REF.: DRAINAGE REPORT FOR THE WAL-MART SITE AT
COORS & RIO BRAVO BOULEVARD

The District has reviewed the grading and drainage plan for the above referenced. The following comments must be addressed prior to construction:

Re: Wal-Mart South Drainage Report
Engineer Stamp date 2-25-04 (P10/D4)

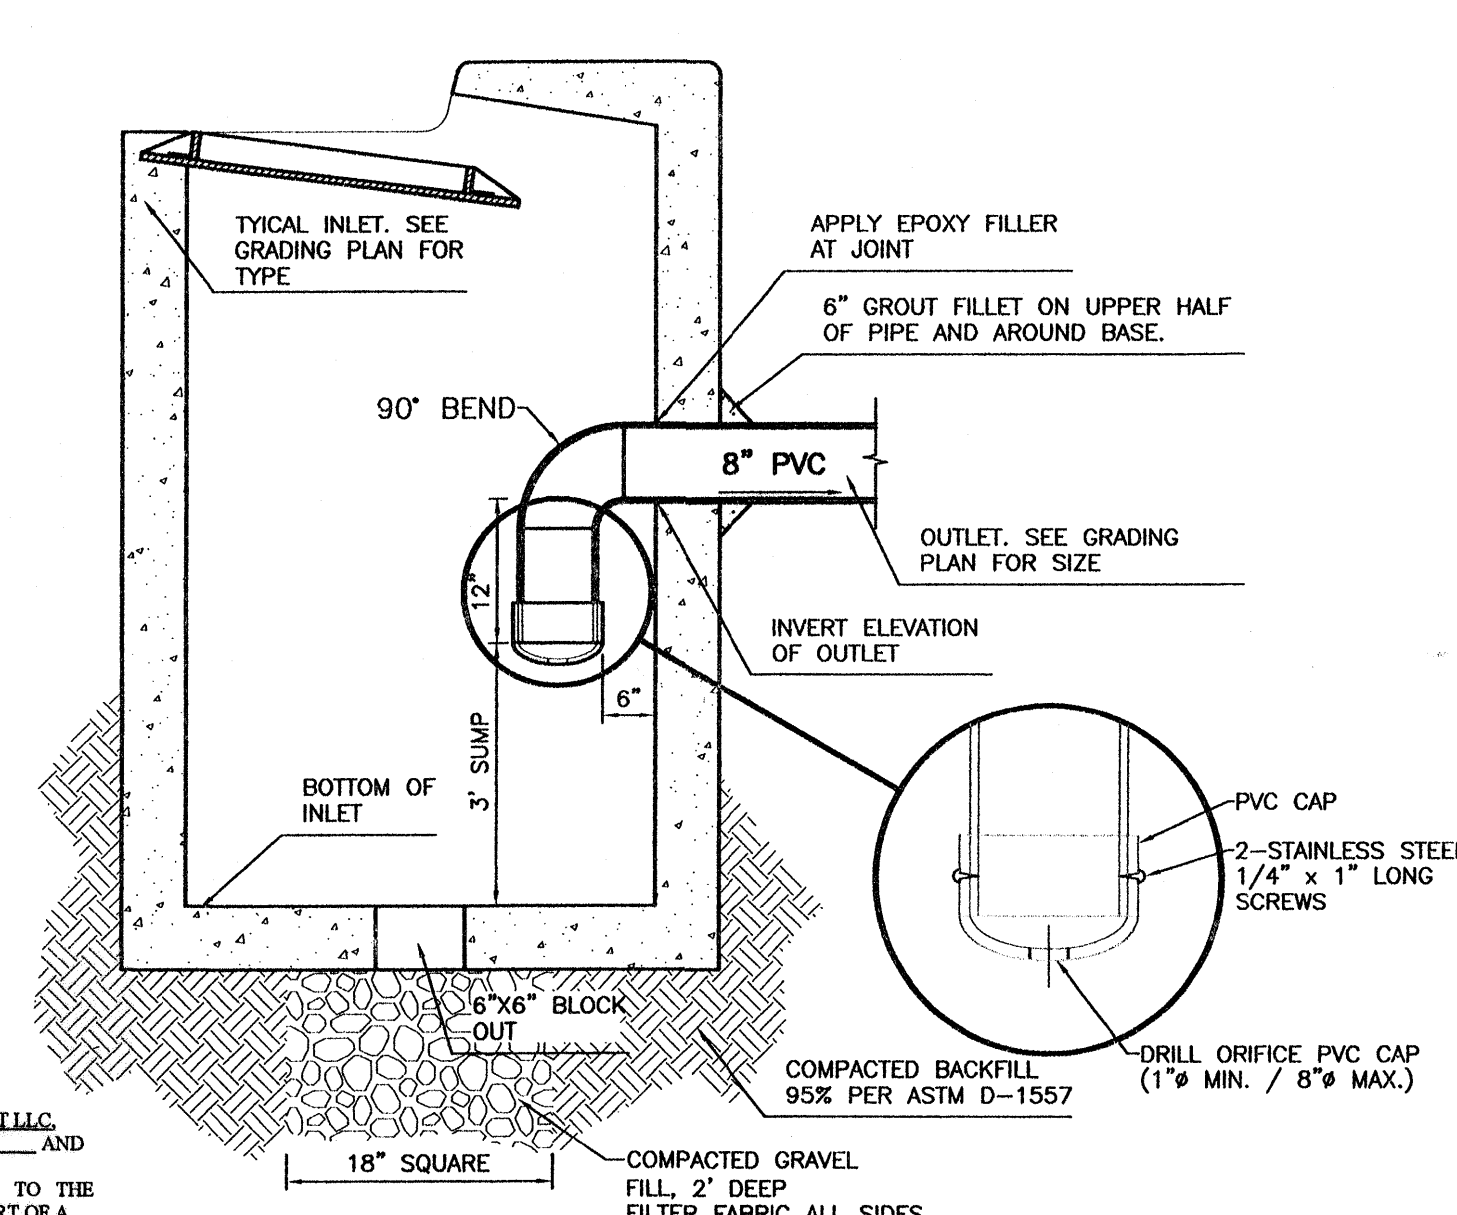
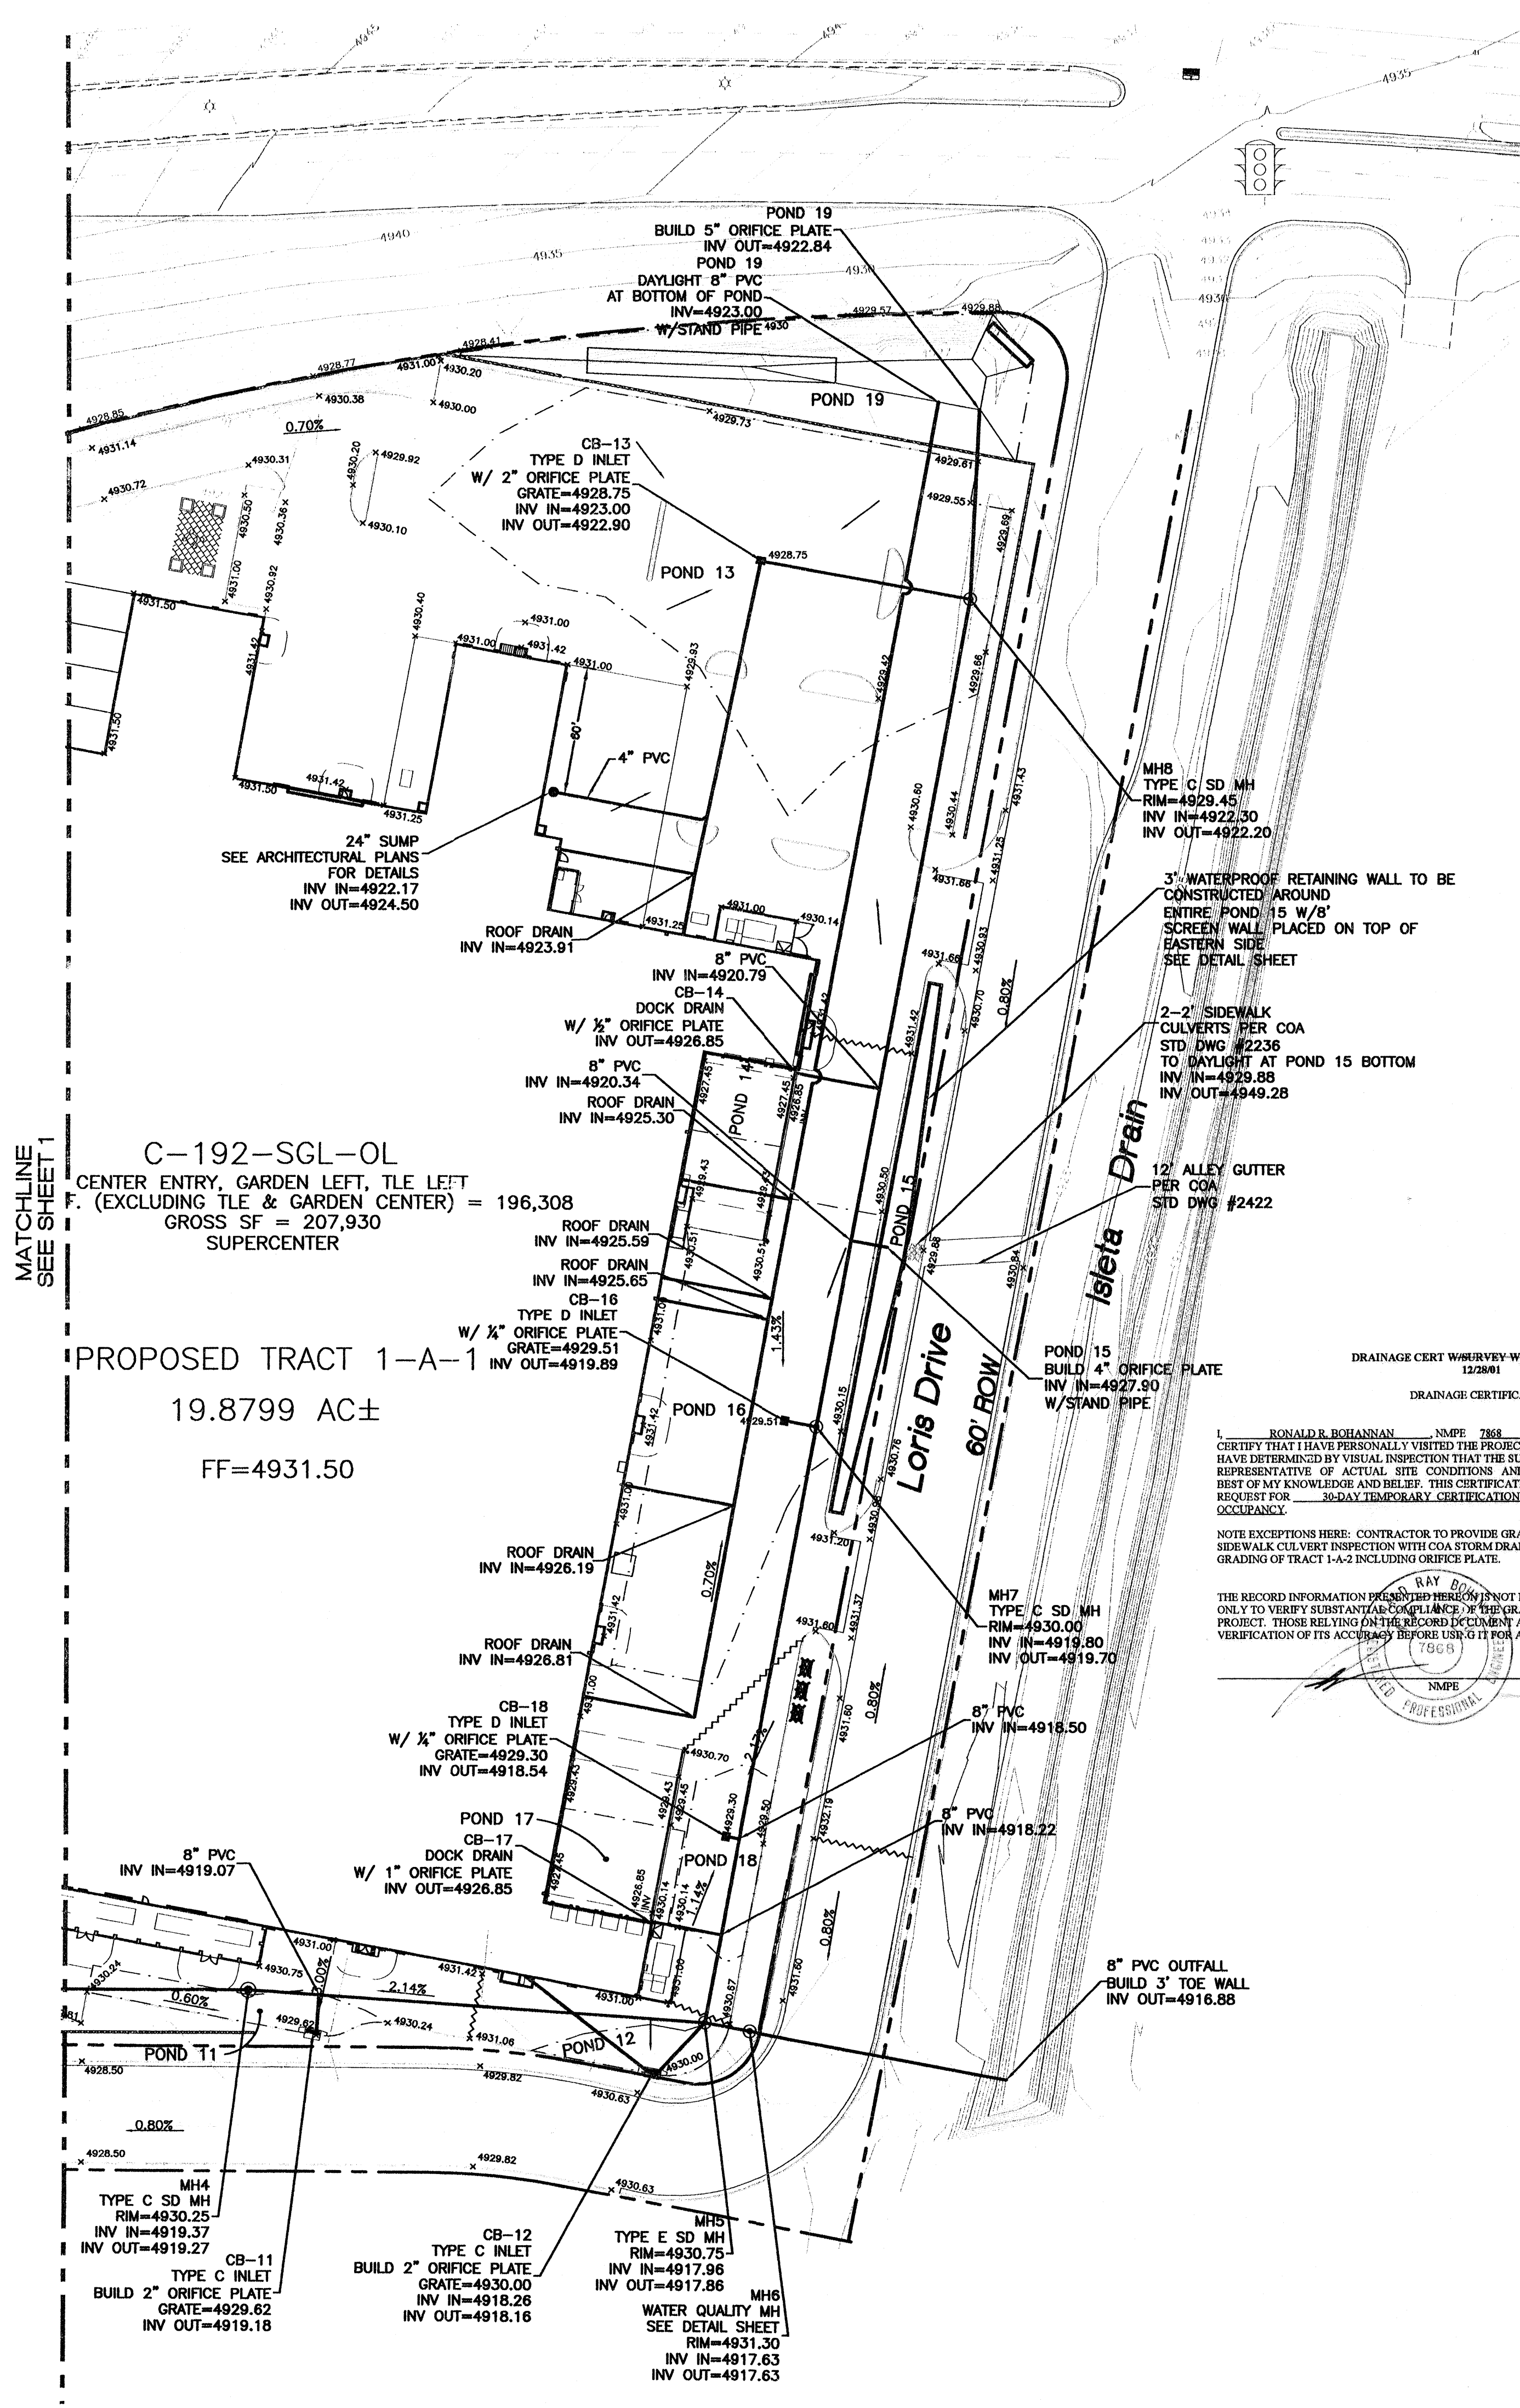
- Please provide written concurrence from MRGCD for the connection to the Isleta Drain. The plan should show the improvements for the channel even though it will be built by Work Order.
- A 0.25" diameter orifice will be incredibly hard to keep from getting clogged. I think these particular inlets should have a detail for removing debris away from the orifice.
- Since the plat is already filed and some of your ponds are accepting public water from the streets, public easements must be provided and an agreement and covenant will be necessary. Since your client is an out-of-town corporation, I would be willing to make this a condition of Certificate of Occupancy but please begin this process as soon as possible.
- Ponds 9, 15 and 19 must have a standpipe outlet with an overflow weir.
